Our Ref: AW/354/18/HH
Your Ref:

Town & Country Planning Act 1990 (as amended)
Town & country Planning (Development Management Procedure) (England) Order 2015
Application for Planning Permission for Works or Extension to a Dwelling

Development New vehicular access & permeable composit material to front garden for parking.
Location Queensbury 4 Aldwick Street Aldwick

block plan
1 : 500

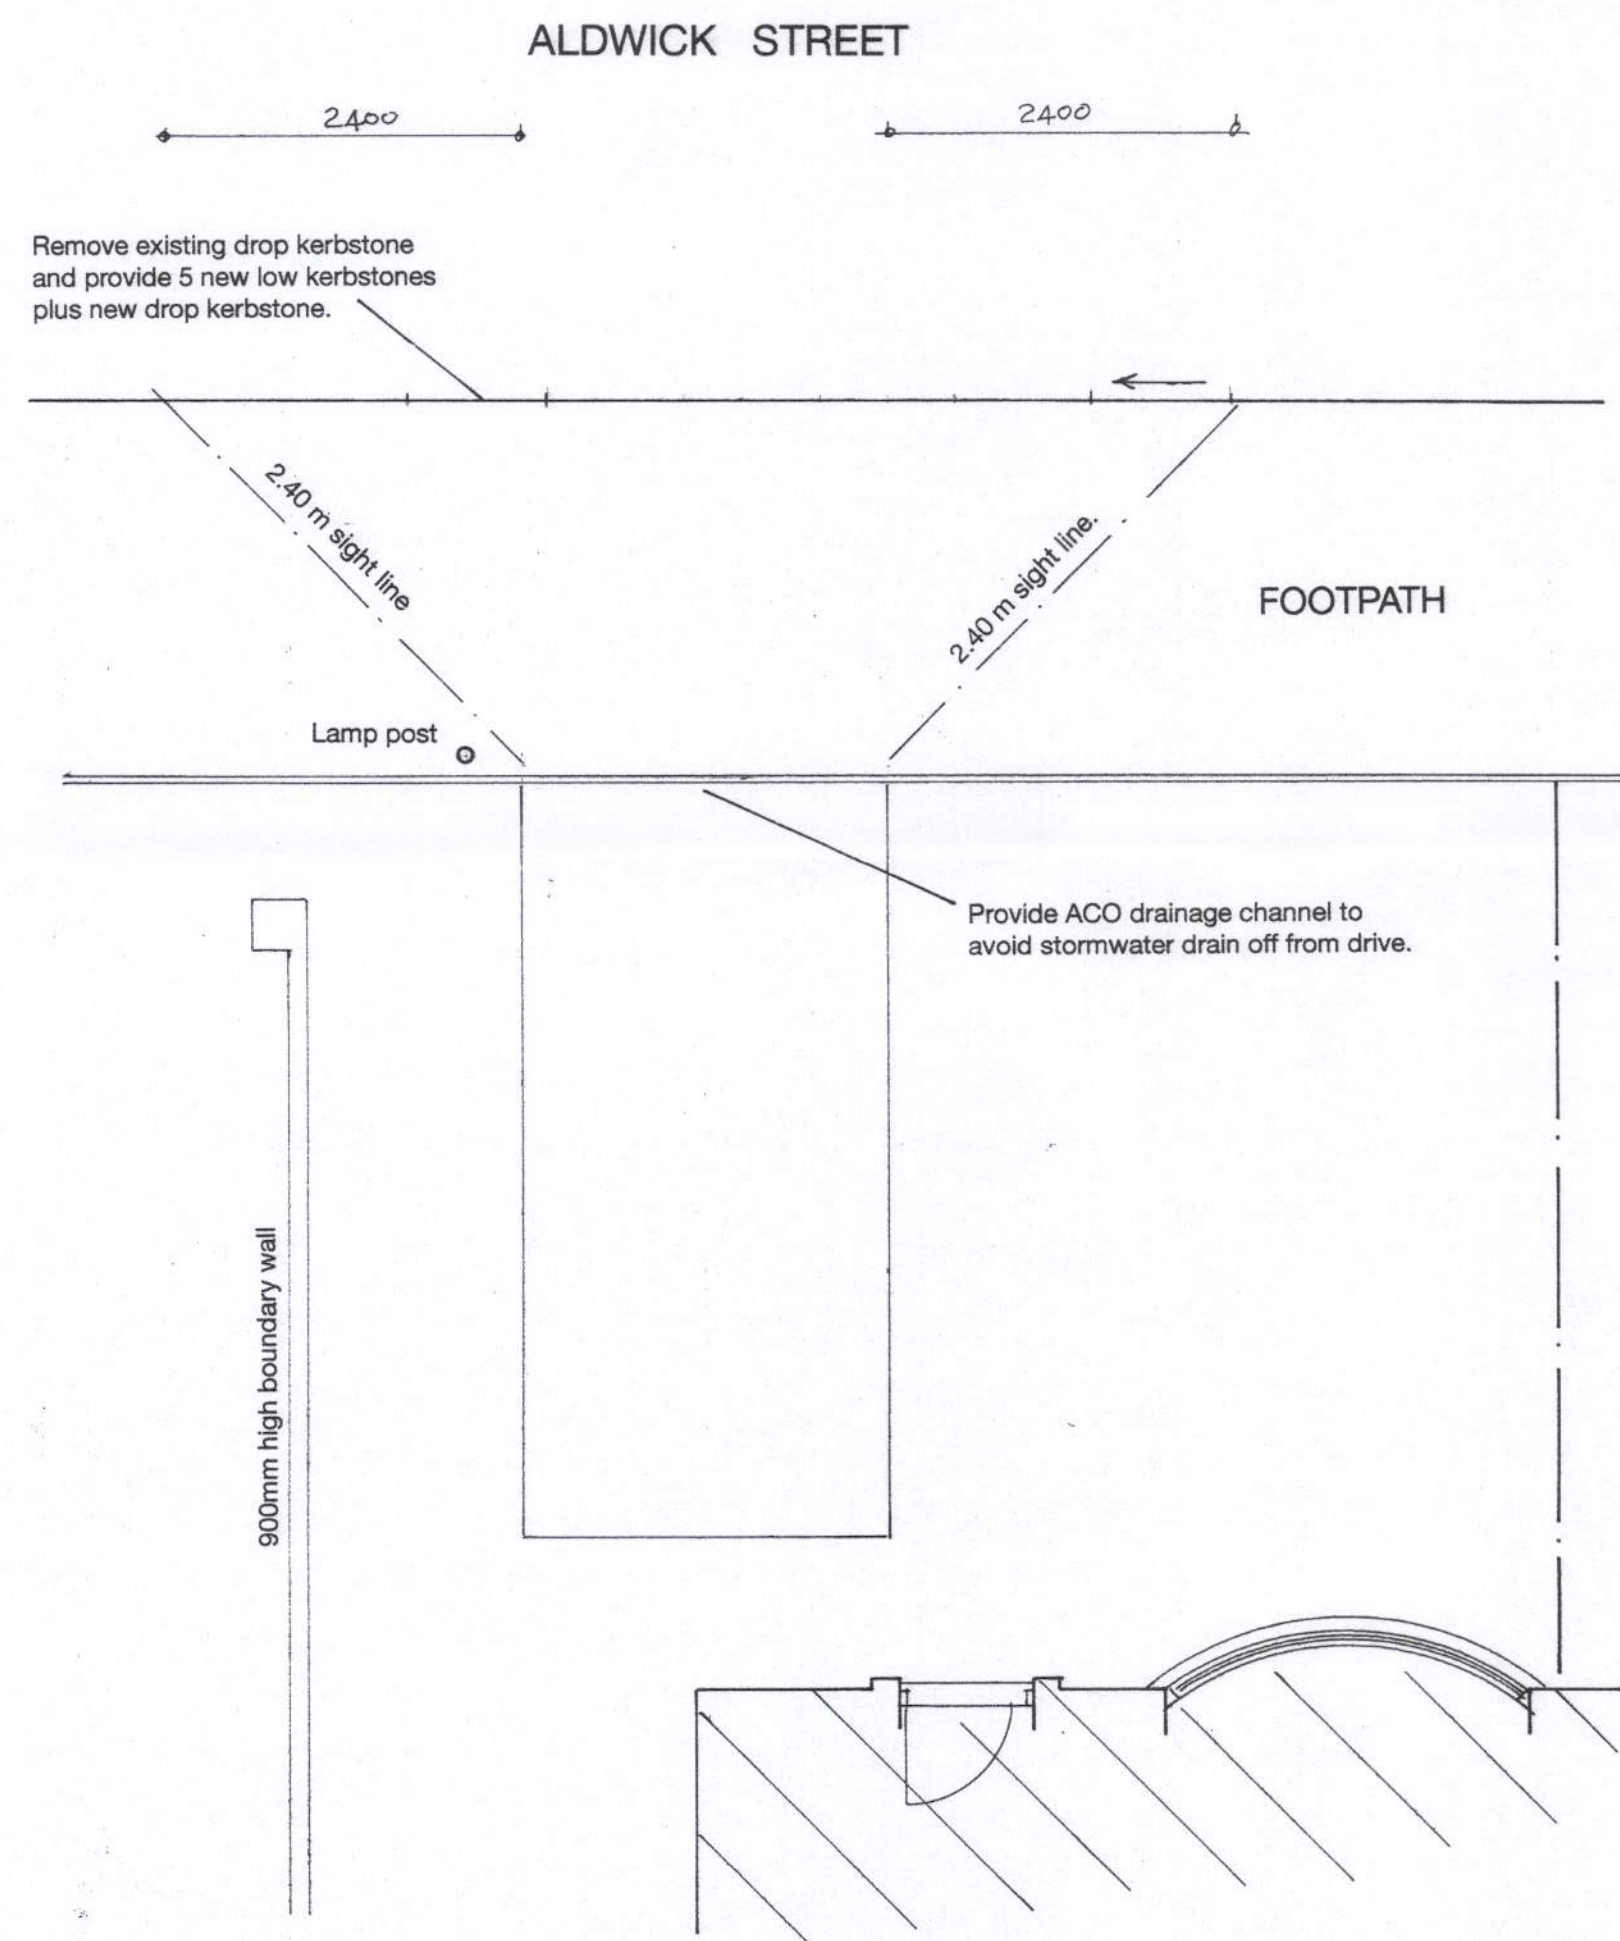
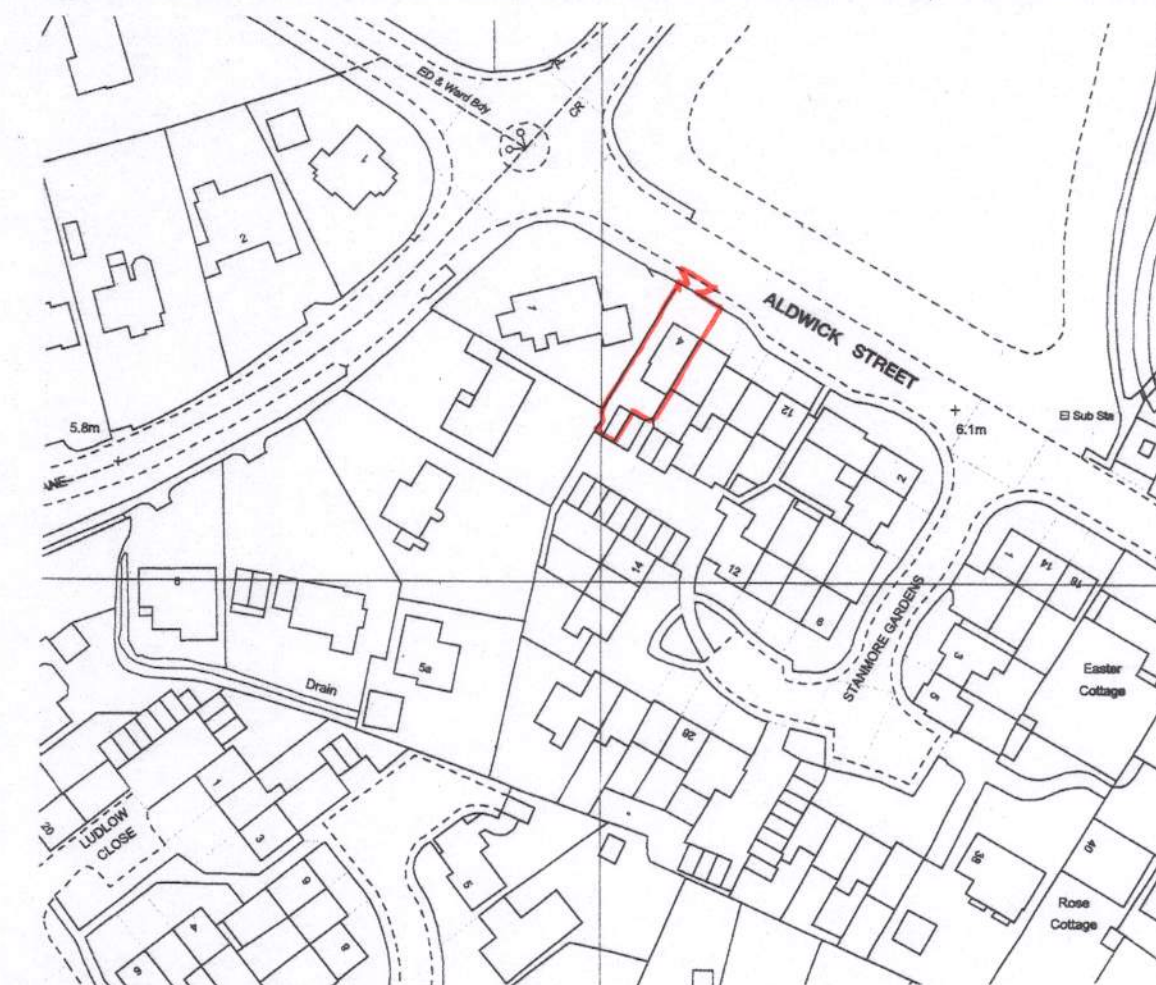
Please provide visibility splays on the block plan. A visibility splay is formed by measuring to a point 2.4m back from the carriageway in the centre of the driveway or entrance. A line (70m long in the case of a 30mph limit) is then drawn to the right, to a point where it strikes the near-side edge of the carriageway.
